From: Anita Gardner
Sent: 21 January 2019 10:24
To: Karen Parsons
Subject: FW: A/146/18/PL - New dwelling . Land adjacent to 4 Gladstone Cottages, Angmering

From: Lauren Willard [REDACTED]
Sent: 17 January 2019 14:08
To: Anita Gardner
Subject: A/146/18/PL - New dwelling . Land adjacent to 4 Gladstone Cottages, Angmering

Plans and Elevations 1:100

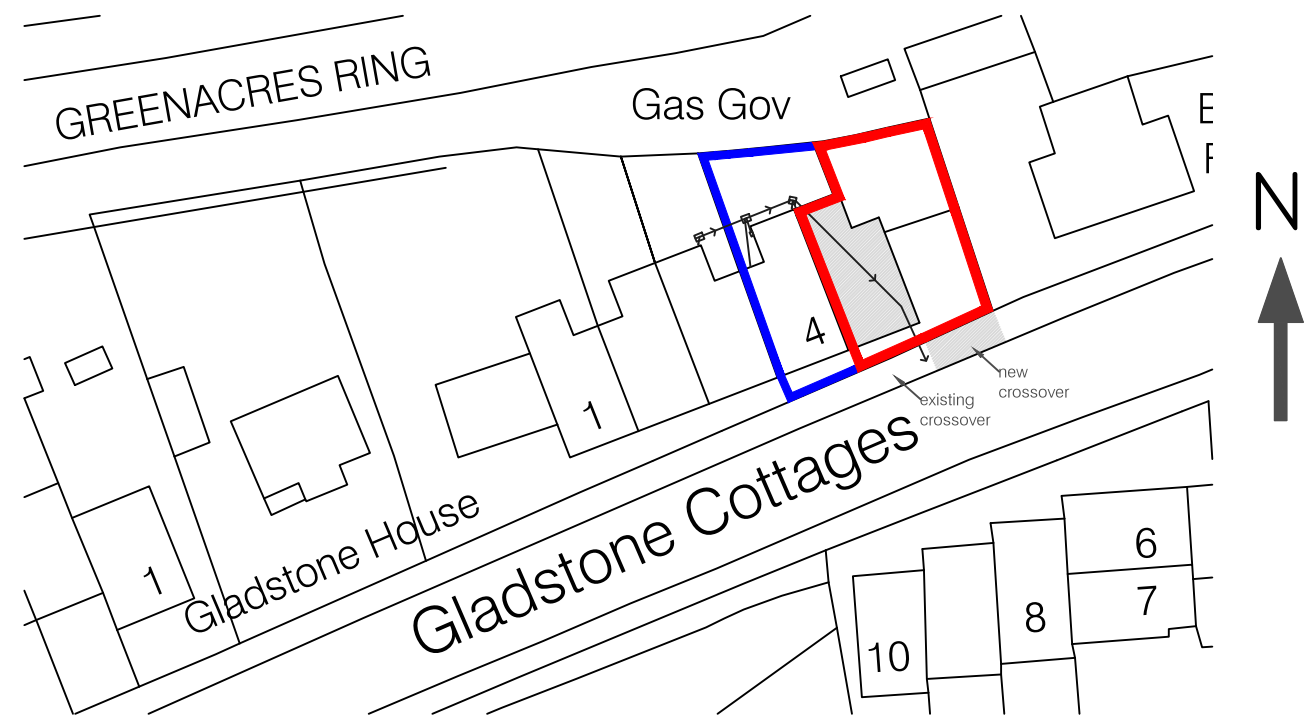
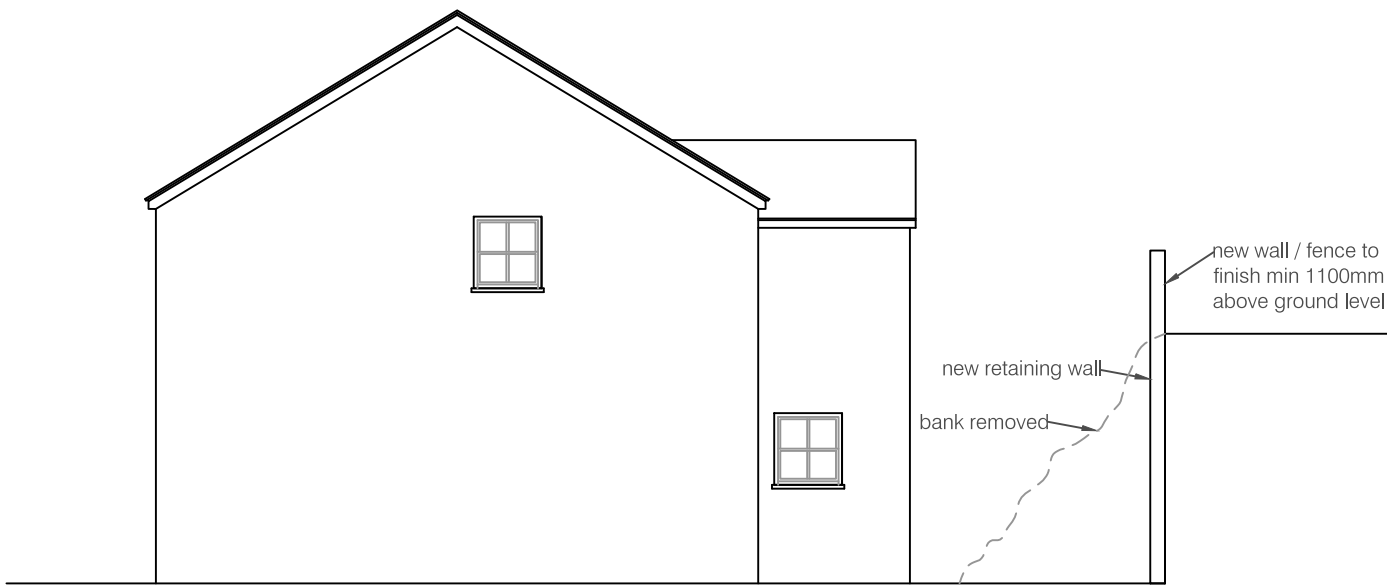
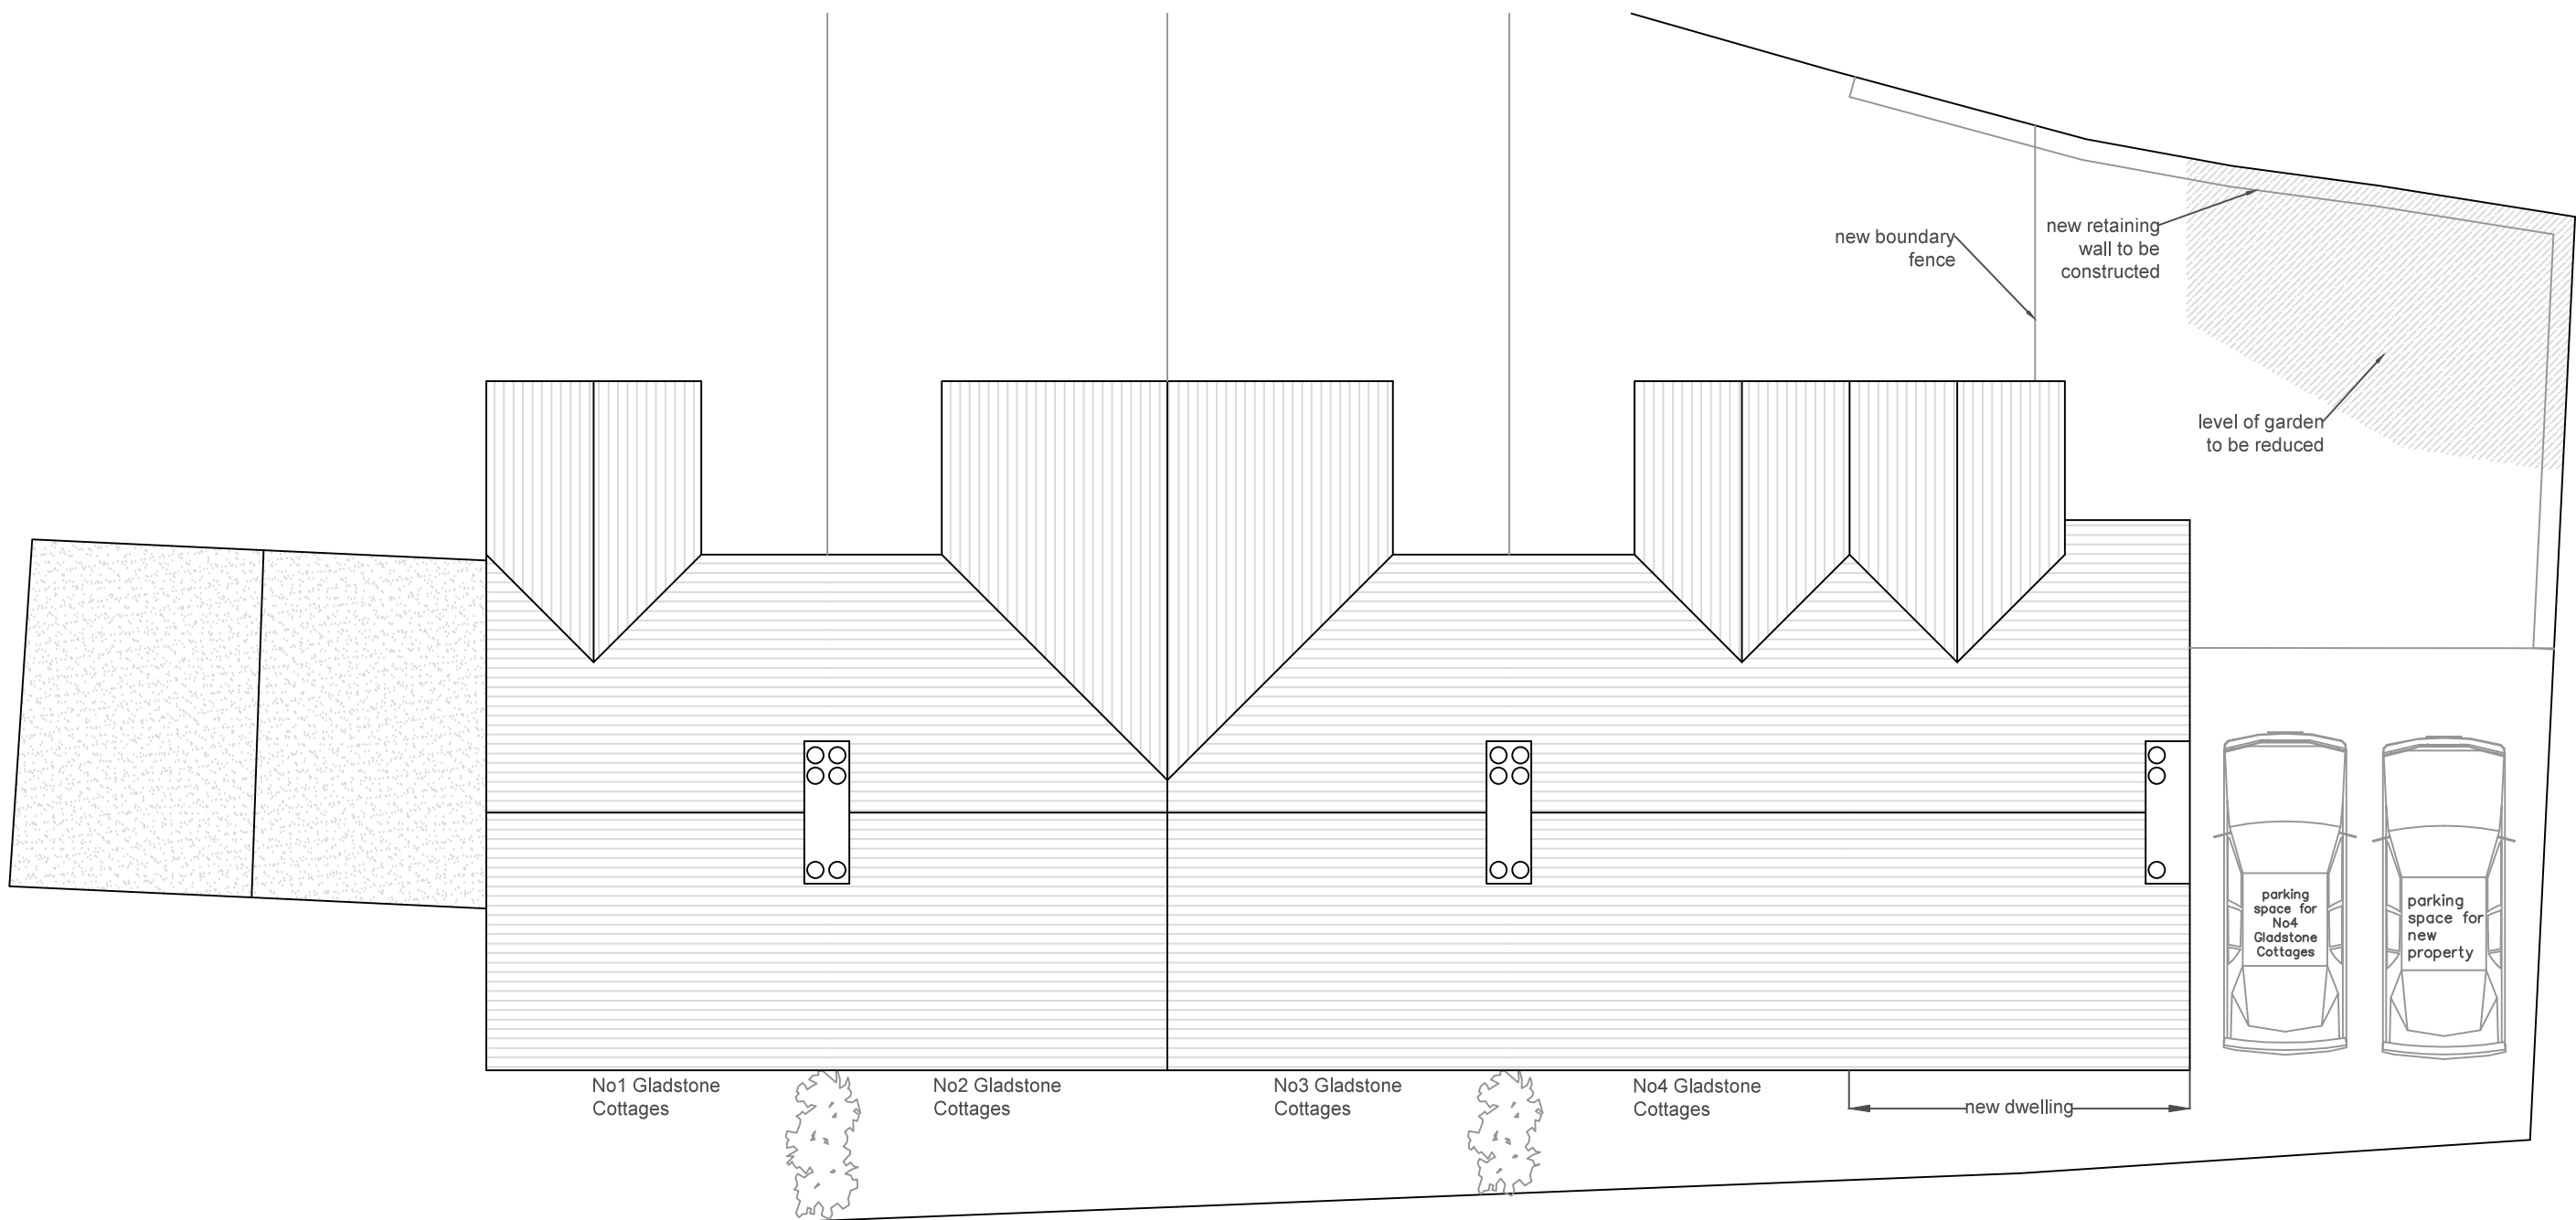
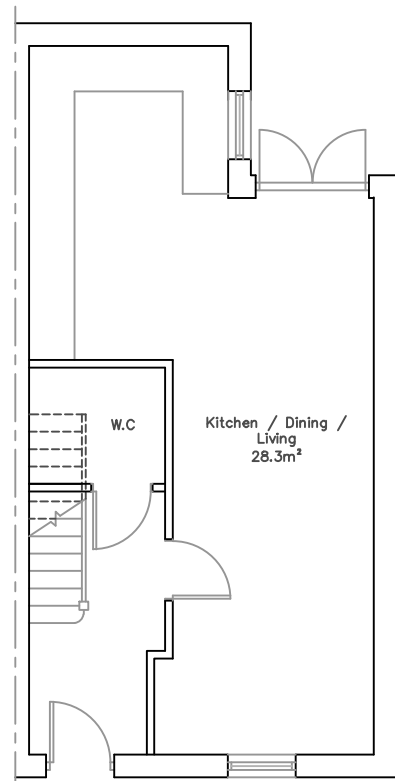
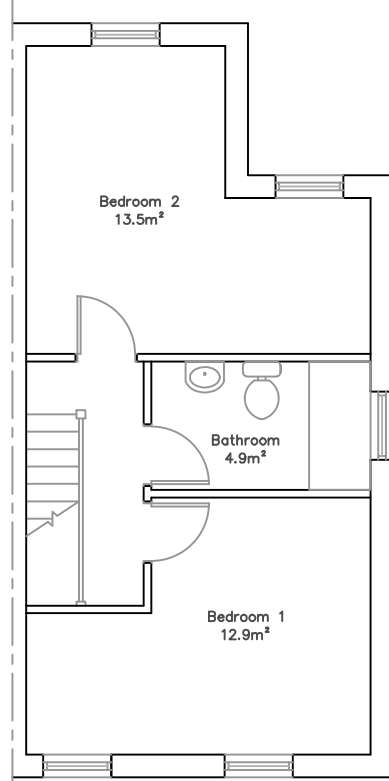
Please find attached the amended drawing which has been revised to show the boundary fence between No.4 and the proposed new dwelling moved over. The two properties now have gardens of a similar area and are in keeping with the gardens of No 2 & No 3. I have annotated one of the rear windows to be obscured and non-opening within 1700mm of finished floor level as we discussed.

I have also added an additional window to the bedroom at the front of the property as I was hoping this could be considered. If this is not acceptable would a high level one on the side elevation be considered?

I have had a brief word with Juan and can advise that the application is likely to be refused given the lack of garden area left to serve the existing dwelling. A property in this location would be likely to be acceptable in principle subject to adequate garden area being provided to the host property. I will be writing my report at the beginning of next week and would appreciate your agreement to an extension of time until 25-01-2019 to allow for signing off following completion of my report. Alternatively you may wish to withdraw the application and consider resubmitting with a detached dwelling and a greater rear and some side garden area to the main property. Please let me know how you wish to progress?

I have discussed this change with Juan, it is acceptable and won't need re-advertising . I will process accordingly. On this basis, can you agree to an EOT until 31-01-2019 to allow for processing, report writing and issuing of the decision?
